Application Ref:	3/2022/0094	 Ribble Valley Borough Council www.ribblevalley.gov.uk	
Date Inspected:	N/A		
Officer:	BT		
DELEGATED ITEM FILE REPORT:		Decision	REFUSAL

Development Description:	Proposed new buildings Unit 1 and Unit 3 to provide storage of animal feed to include hay/straw and machinery .
Site Address/Location:	Bolton Fold Farm, Alston Lane, Longridge. PR3 3BN

PROPOSED ELEVATIONS
 (UNIT 1)

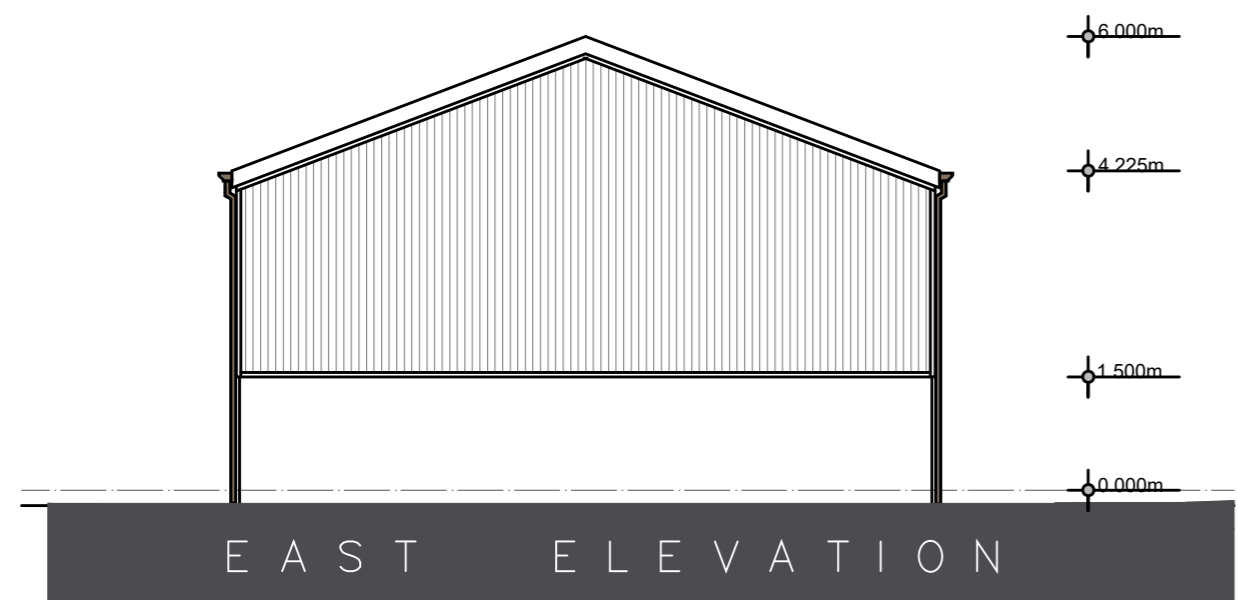
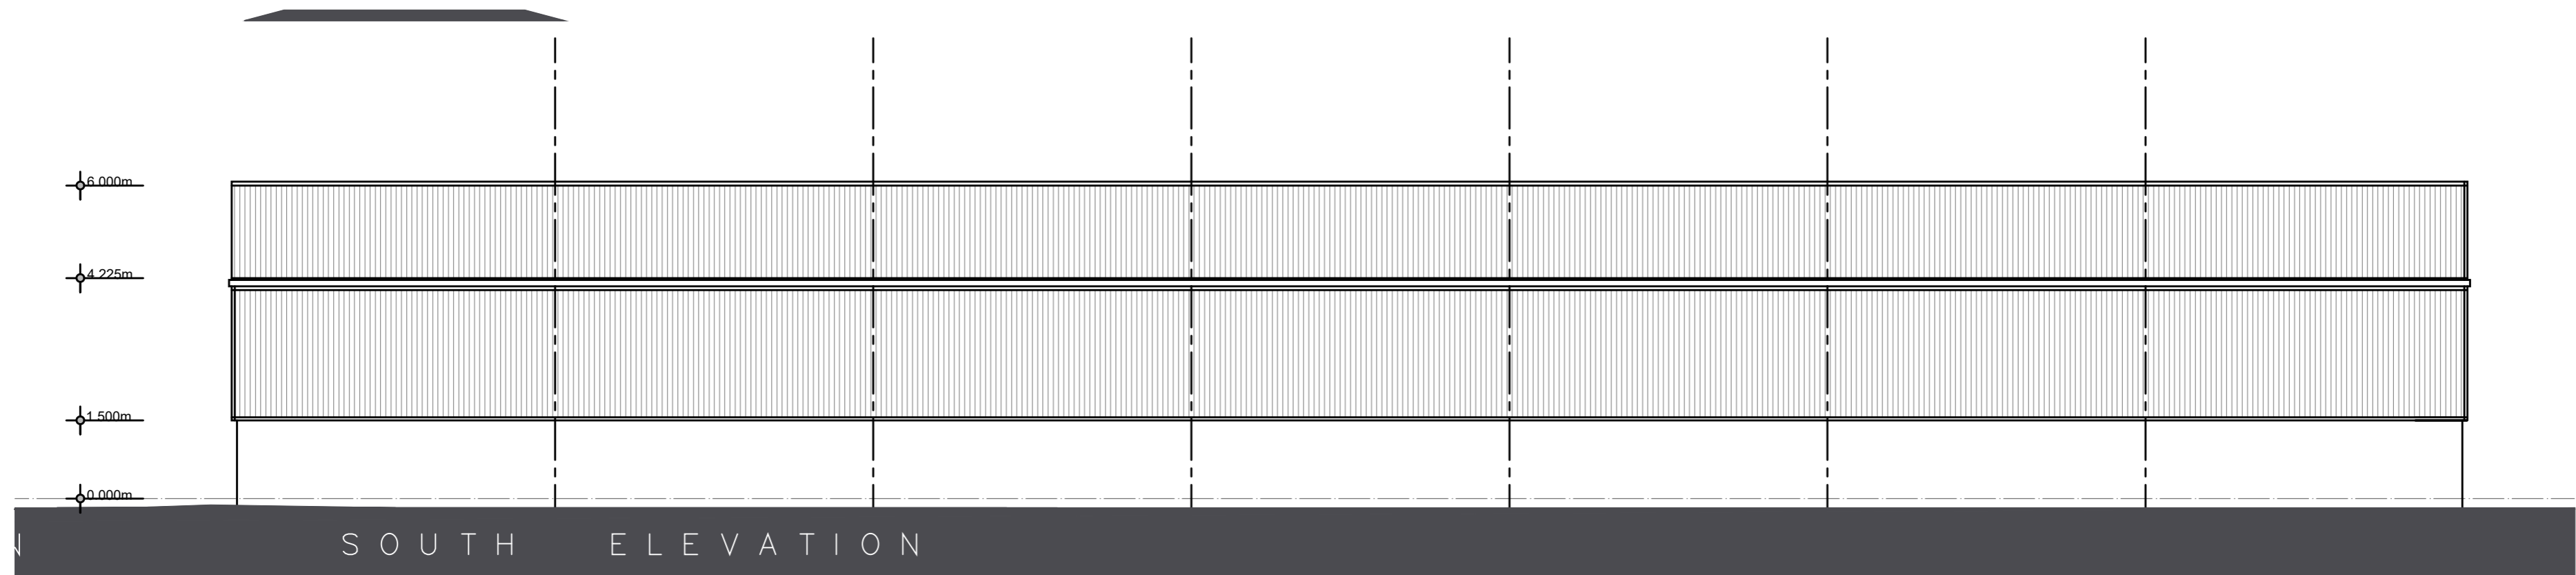
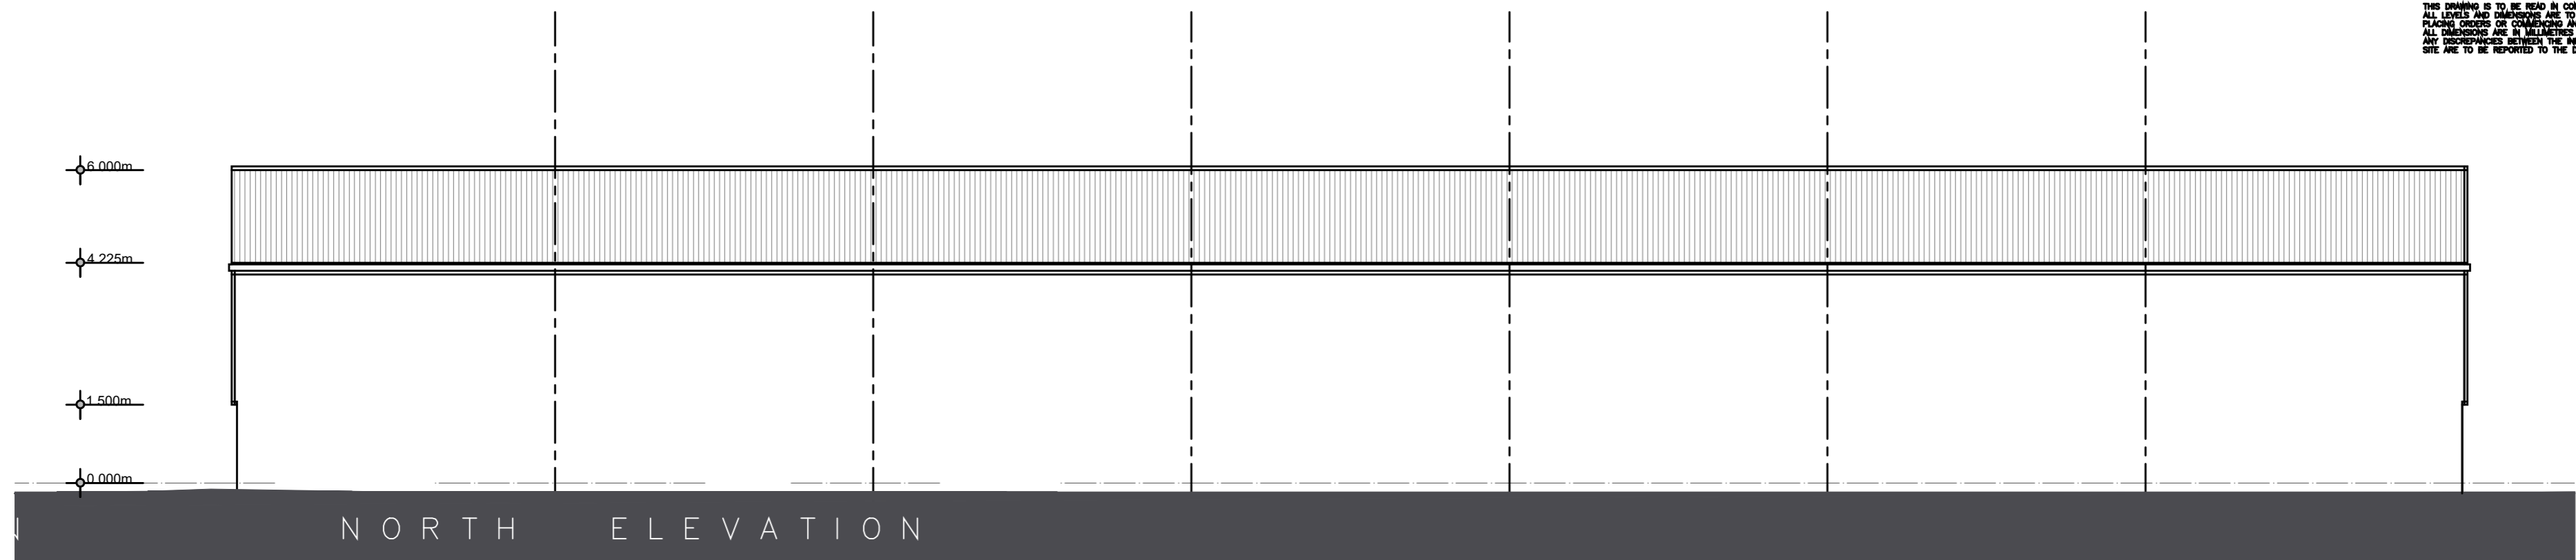
The highest part of the proposed agricultural buildings would be 7 metres

Drawing Title
 PROPOSED FLOOR PLAN
 (UNIT 1)

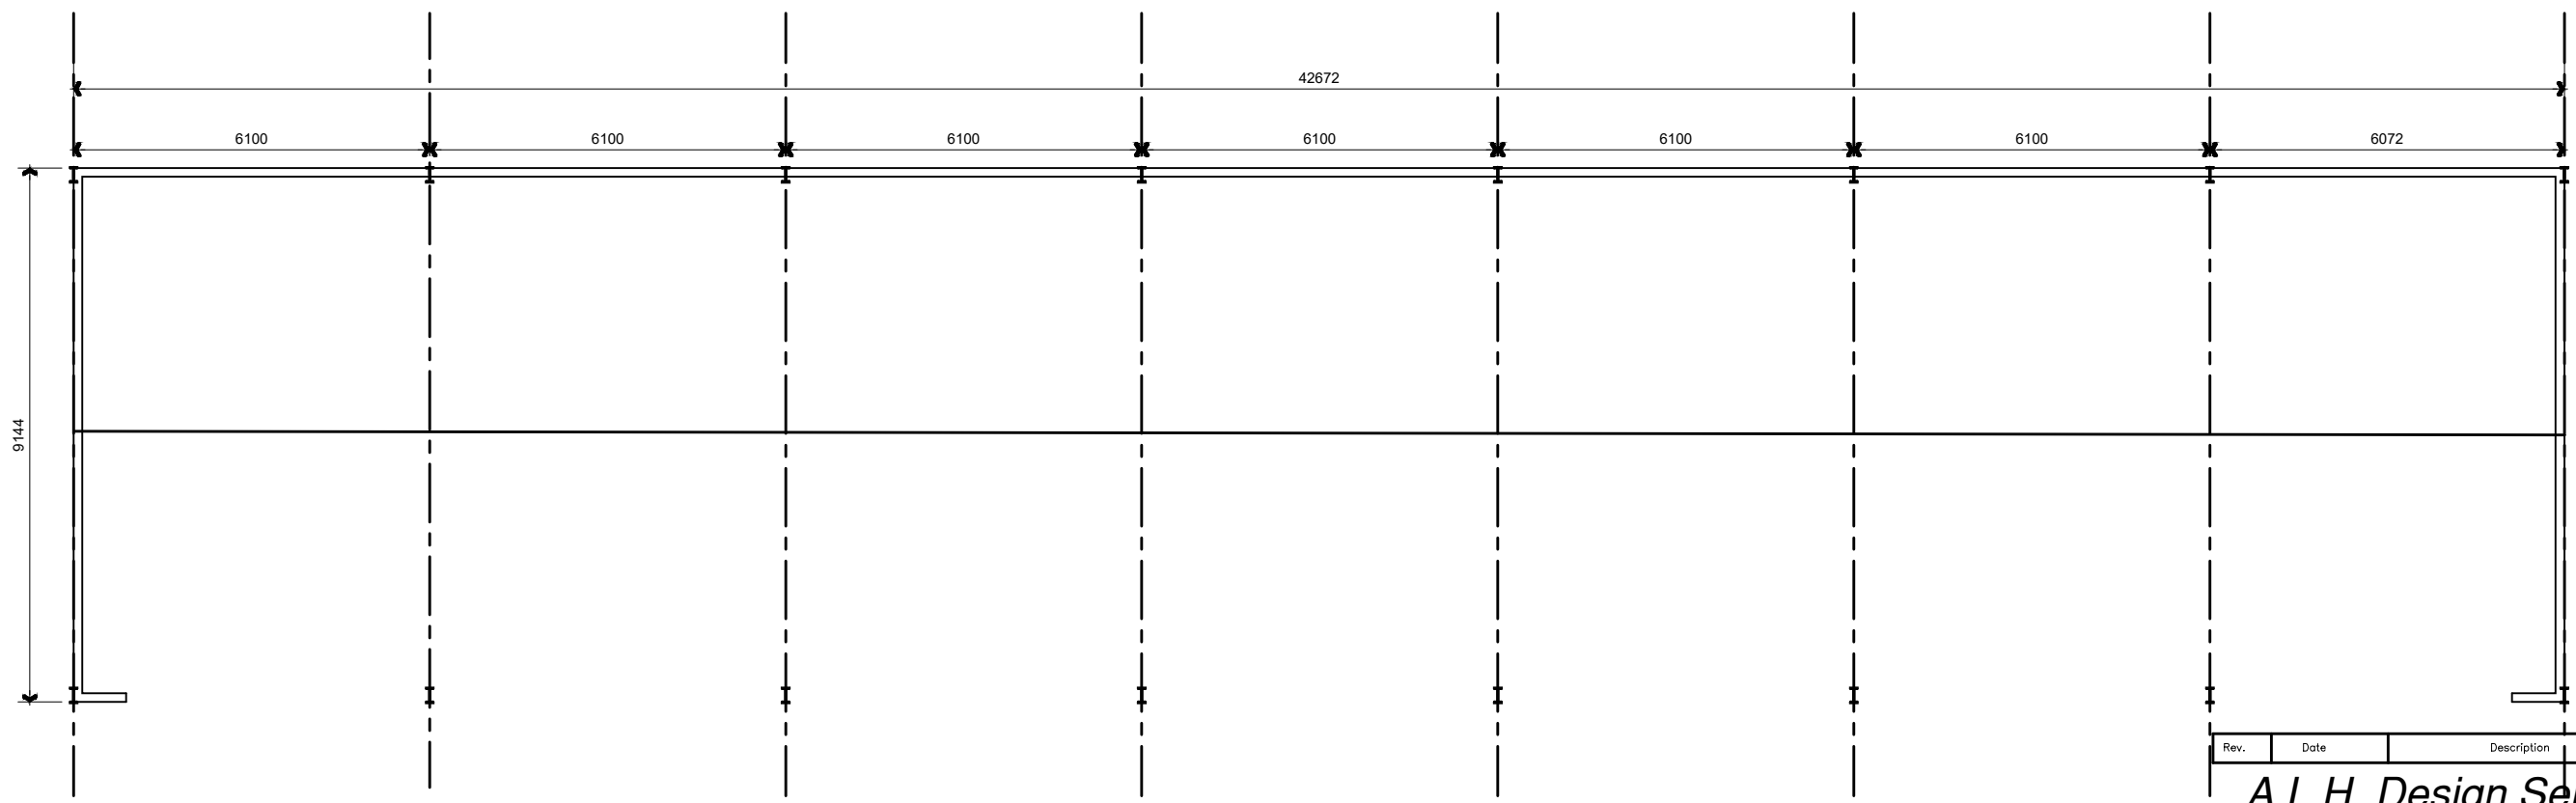
The ground area covered by the proposed agricultural buildings would measure 1132.8 square metres

The proposed agricultural buildings would exceed 1000m² in ground floor area and as such would fail to meet the criteria within Part 6, Class A of the Town and Country Planning (General Permitted Development) Order 2015. Accordingly, prior approval is refused and a full planning application is required.

Drawing Title
 PROPOSED SITE PLAN

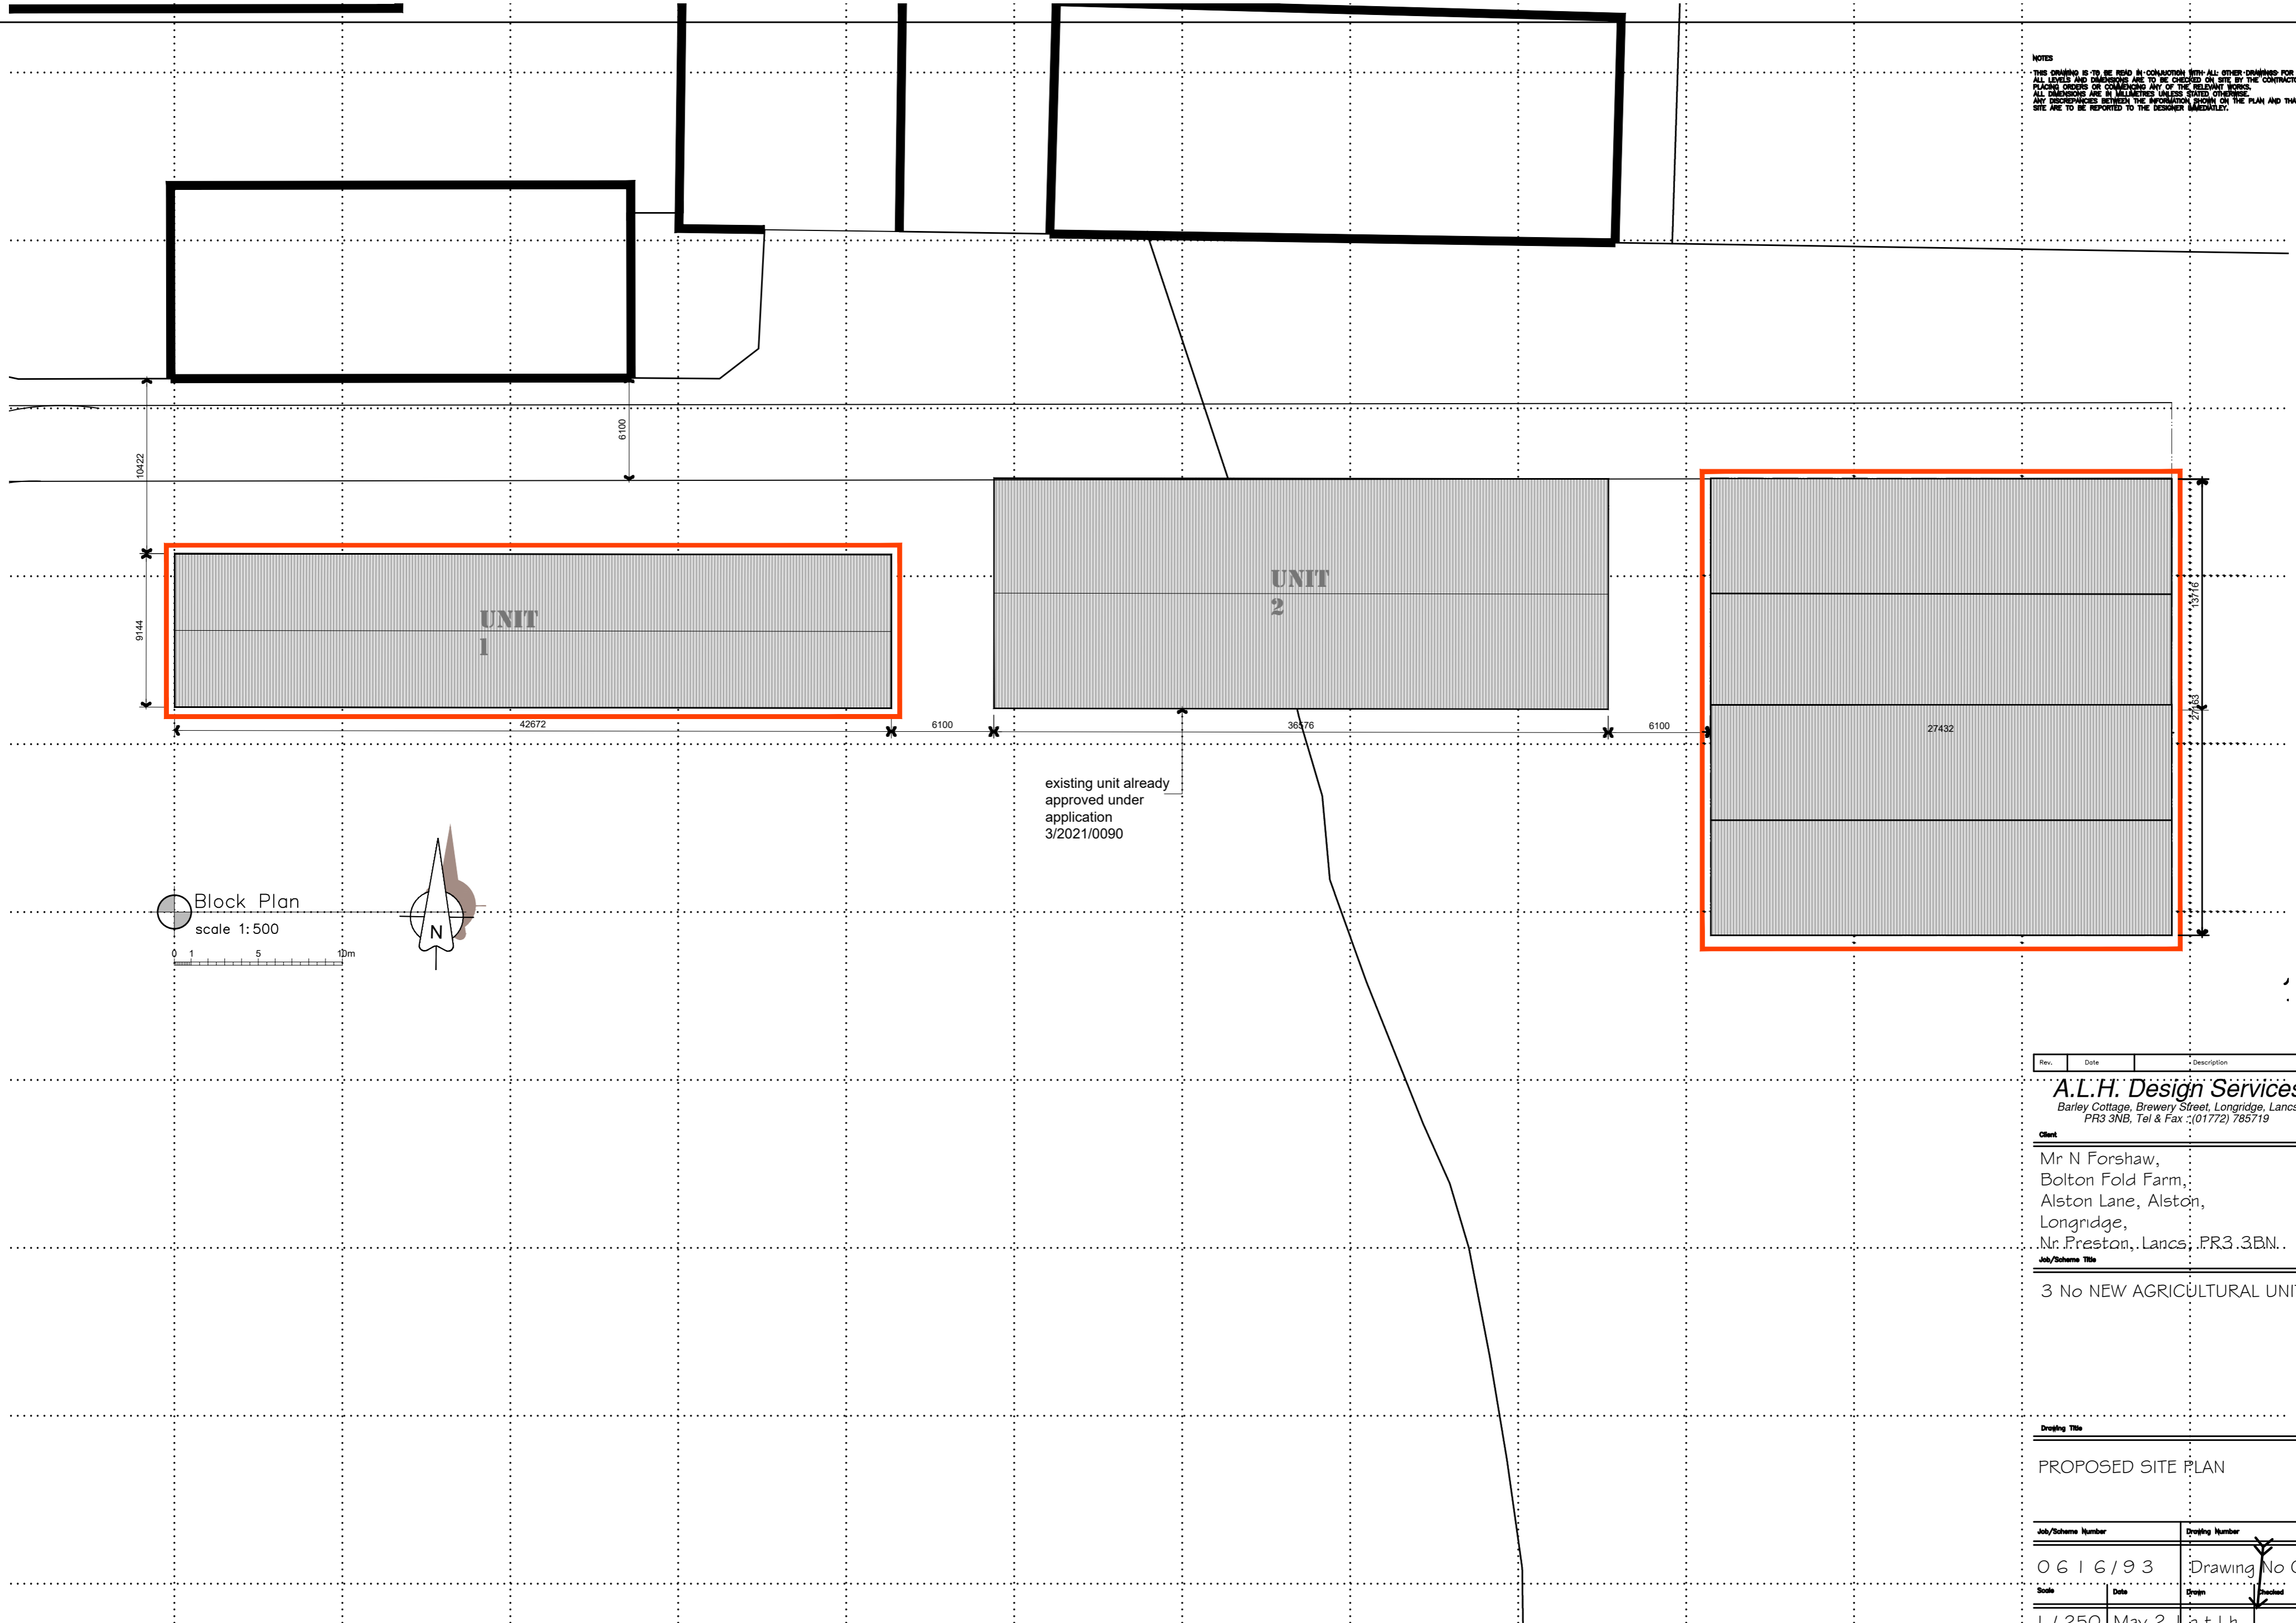
The site for the proposed agricultural buildings is 230 metres from the nearest trunk road or classified road which in this instance is Preston Road
